CITY OF ALBUQUERQUE

January 20, 2006

RE: RINCONADA TRAILS (F-10/D12)
Engineers Certification for Release of Financial Guaranty
Engineers Stamp dated 12/25/2004
Engineers Certification dated 09/01/2005

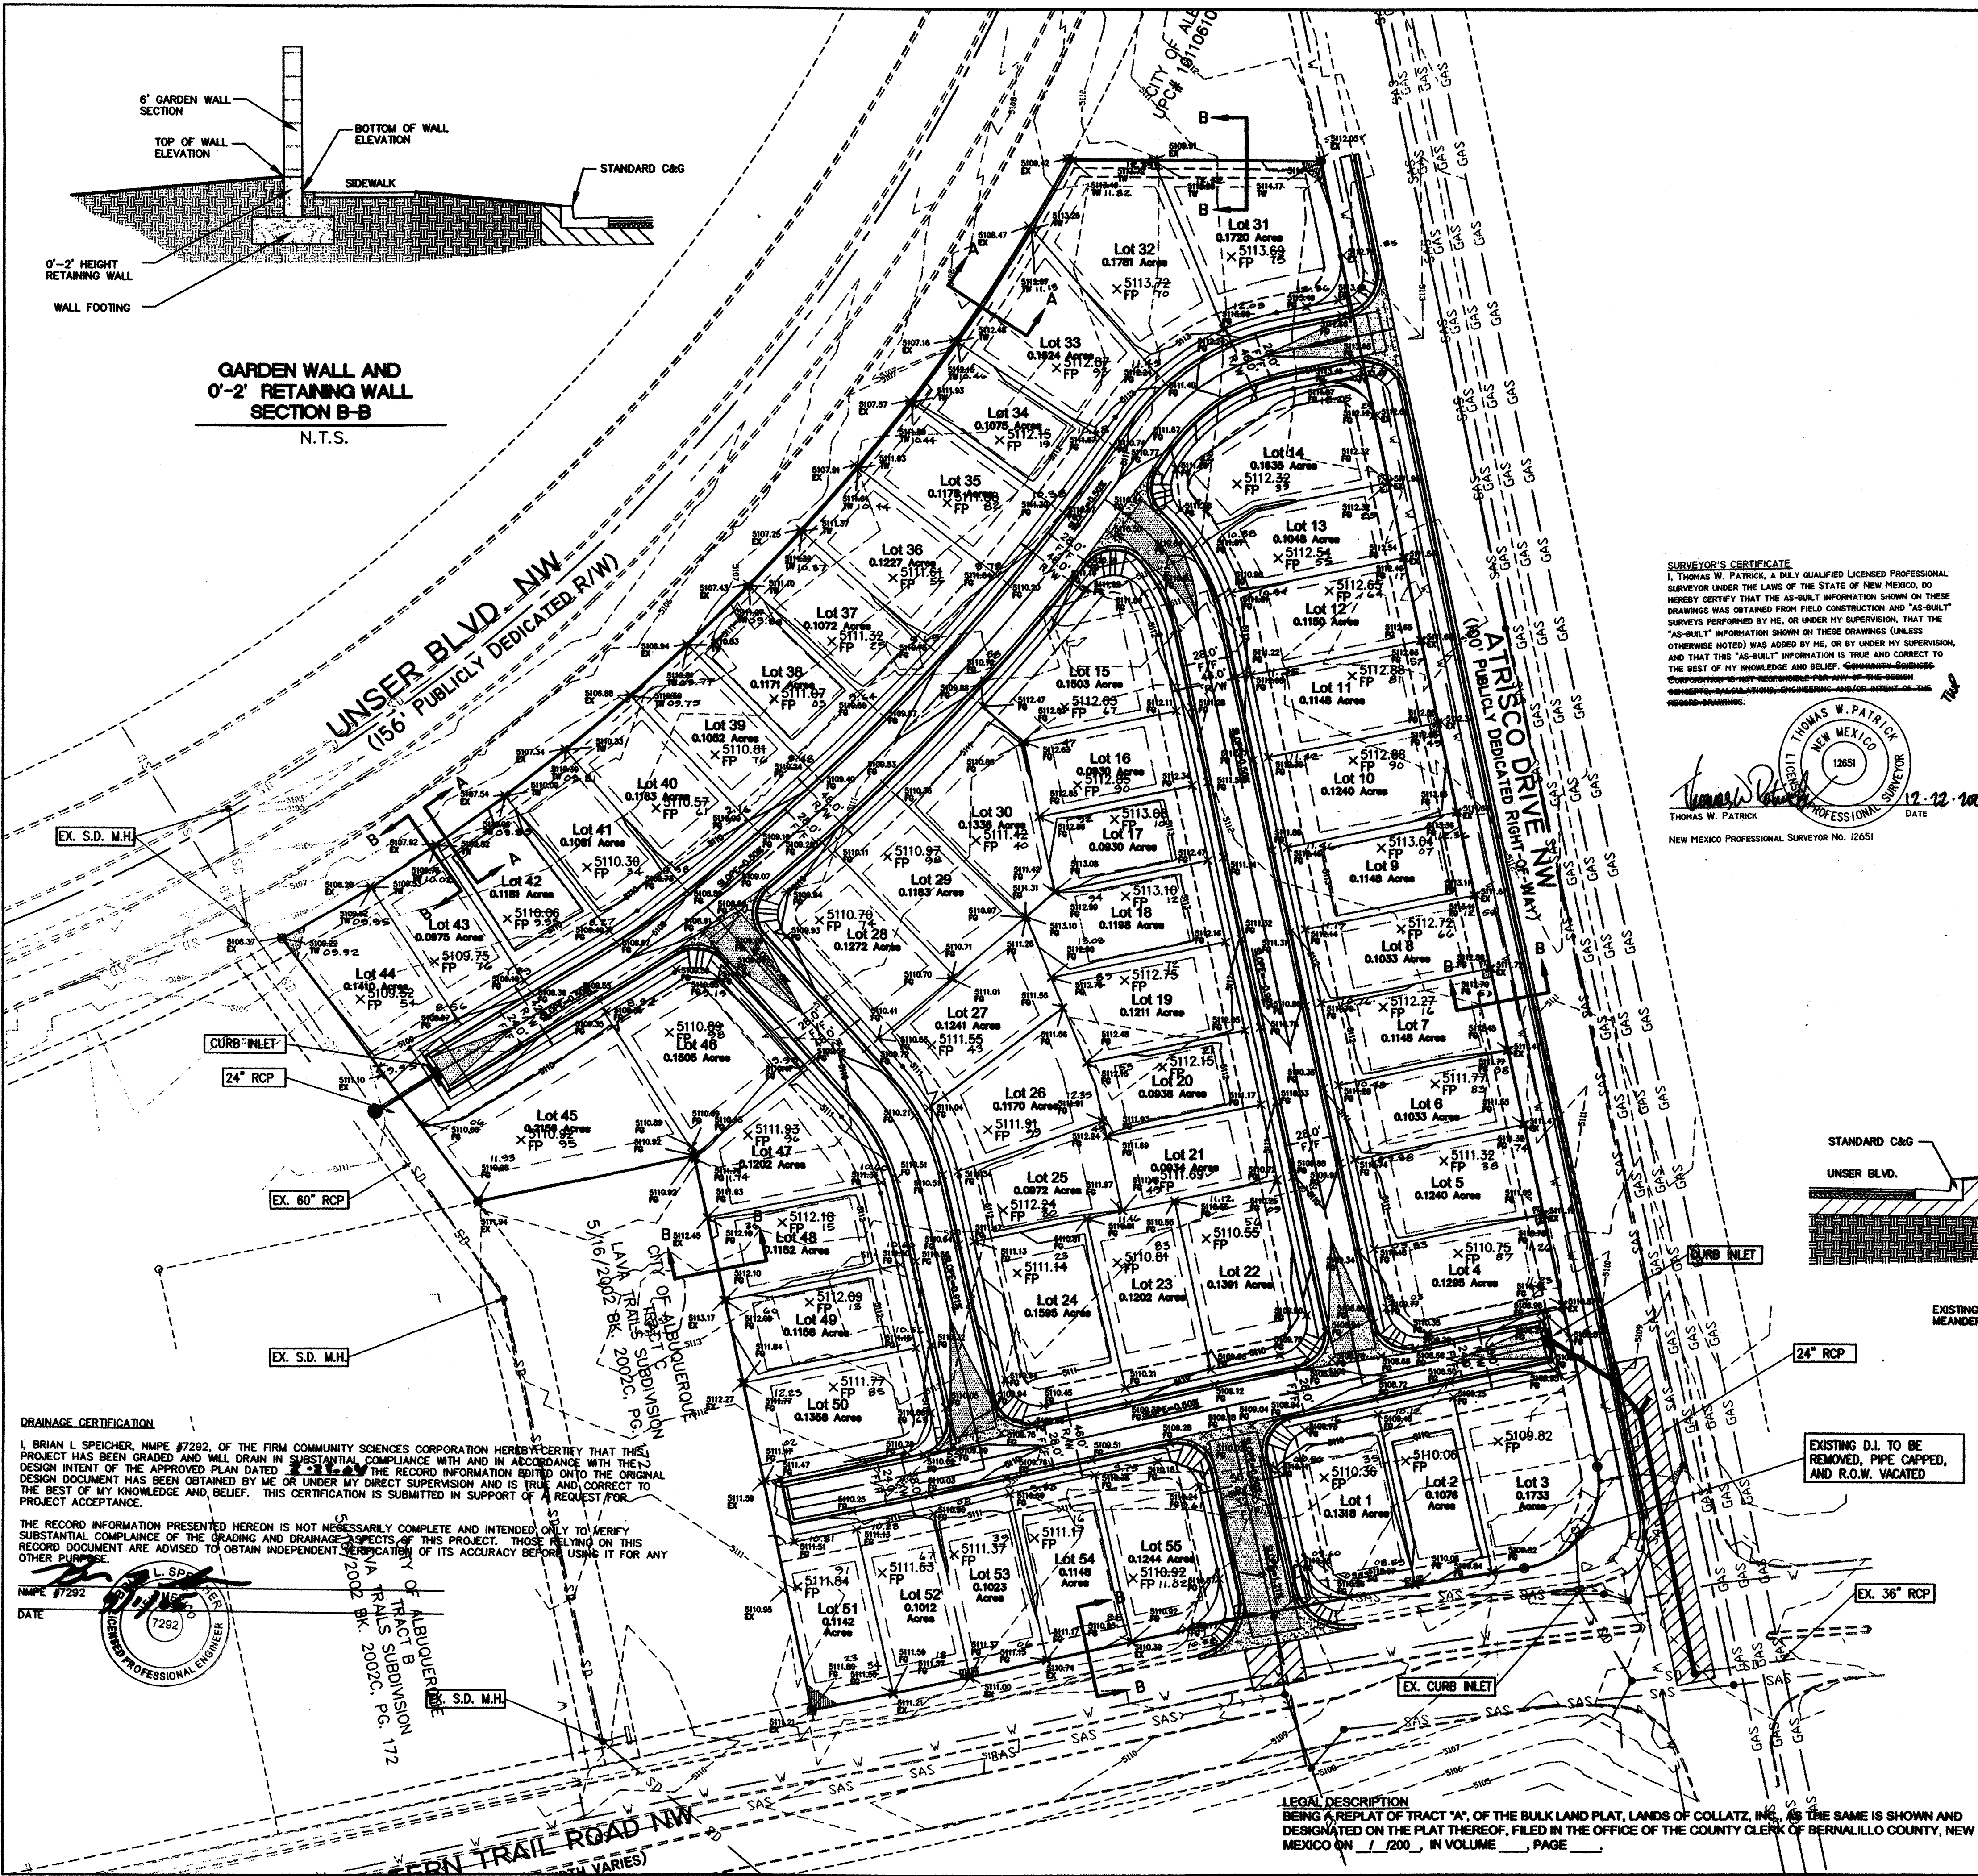
The Grading and Drainage Plan (GDP) you submitted for "SIA/Financial Guarantee Release" appears to be the one in the work order plan set and not the GDP which was approved via correspondence, dated April 28, 2004. Although the submitted GDP is not the correct one, based upon the information provided in your Engineer's Certification Submittal received 01/18/2006, the above referenced plan is adequate to satisfy the Grading and Drainage Certification for Release of Financial Guaranty.
